DECISION DELEGATED TO DEVELOPMENT MANAGER

Application No:	H18-0411-20	Applicant:	Georgian Homes
Proposal:	Proposed change of use of first floor commercial premises into a self-contained flat		
Location:	1b-2 High Street Sutton Bridge Spalding		
Terminal Date:	31st July 2020

First Floor Plan

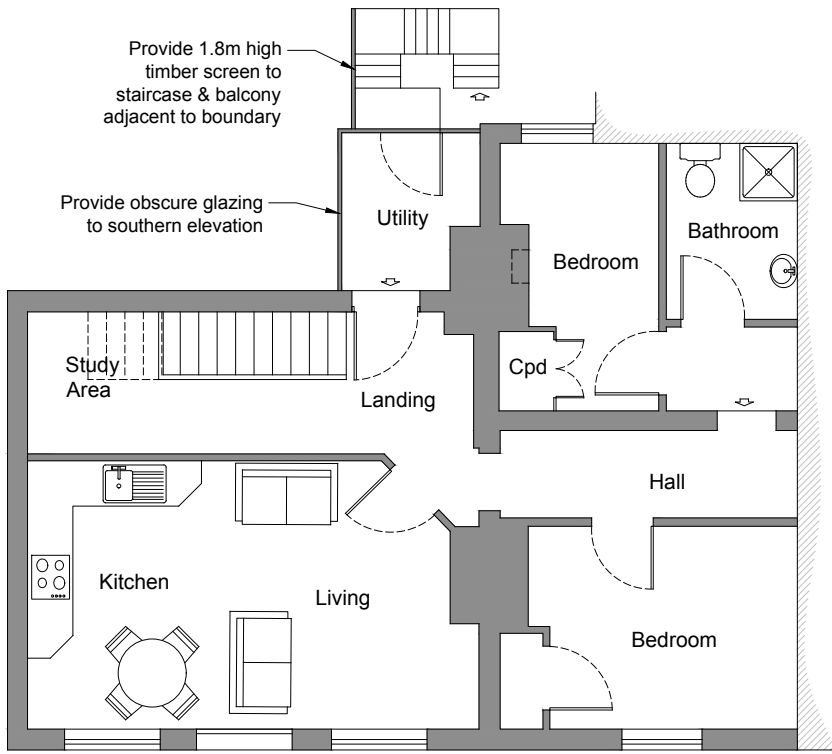
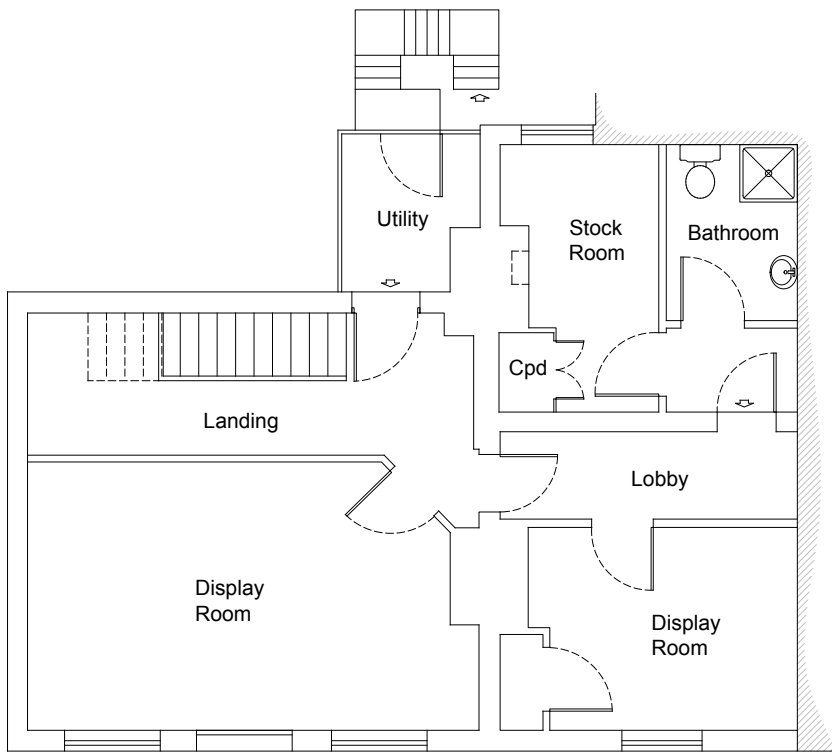
The main entrance to the self-contained flat is via a side alley off High Street. However, there is also a rear entrance via an external staircase, which presently overlooks a neighbouring courtyard garden. However, the applicant proposes to screen the top of the staircase to alleviate this. Obscure glazing would also be installed within the utility room facing south. It is considered that the amenity of neighbouring residents would not be materially harmed in terms of overlooking, overshadowing, overbearing effect, noise and disturbance, etc subject to the aforementioned measures.
